From: Hornby, Mark [Mark.Hornby@lancashire.gov.uk]
Sent: 25 October 2012 15:02
To: Graeme Thorpe
Cc: ENV EPP Customer Service Area East
Subject: FW: Planning application consultation 3/2012/0825P - 50 Derby Road, Longridge

I have no objection to this proposal, subject to the following conditions:

Block Plan

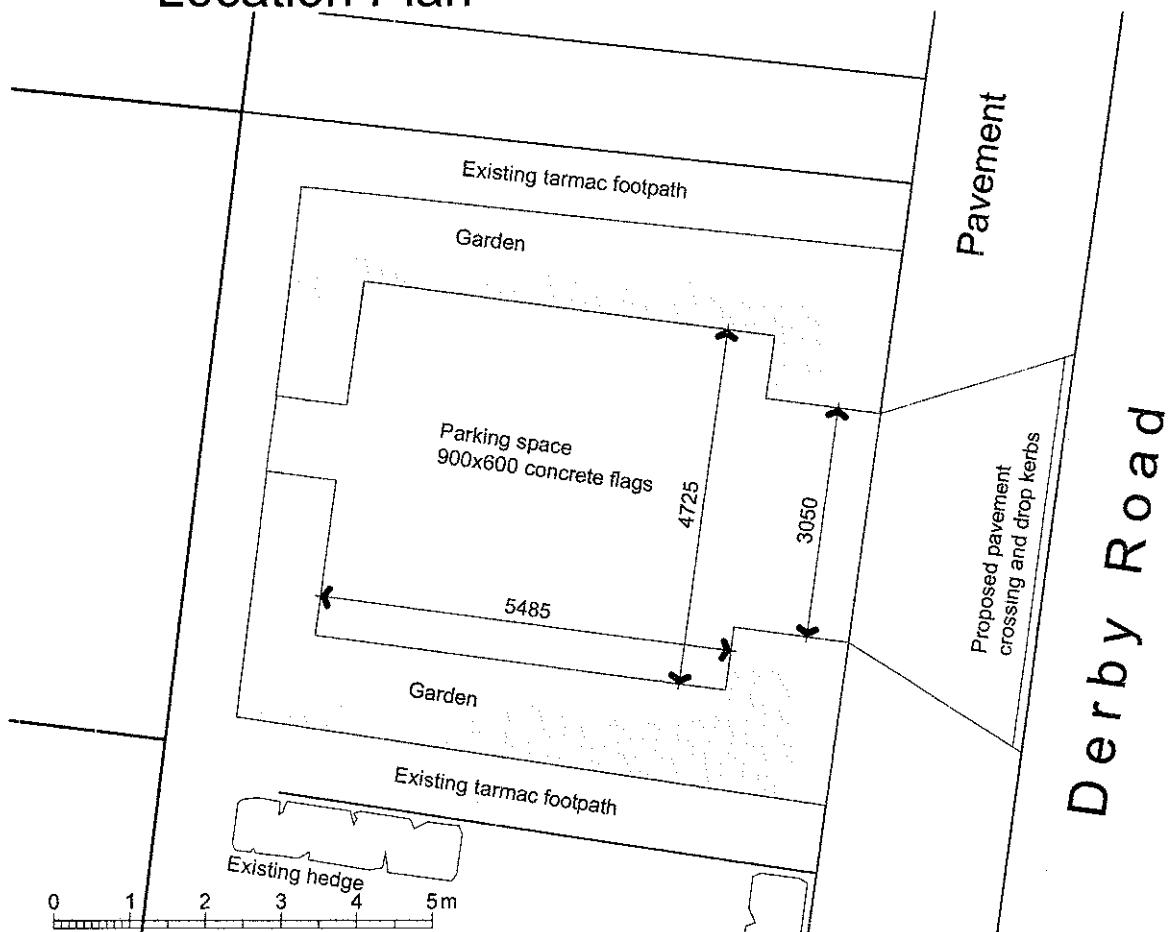
1. The access shall remain ungated. Reason: To permit vehicles to pull clear of the carriageway when entering the site.
2. Before the access is used for vehicular purposes, the proposed parking area shall be appropriately paved in tarmacadam, concrete, block pavours, or other approved materials. Reason: To prevent loose surface material from being carried onto the public highway thus causing a potential source of danger to other road users.
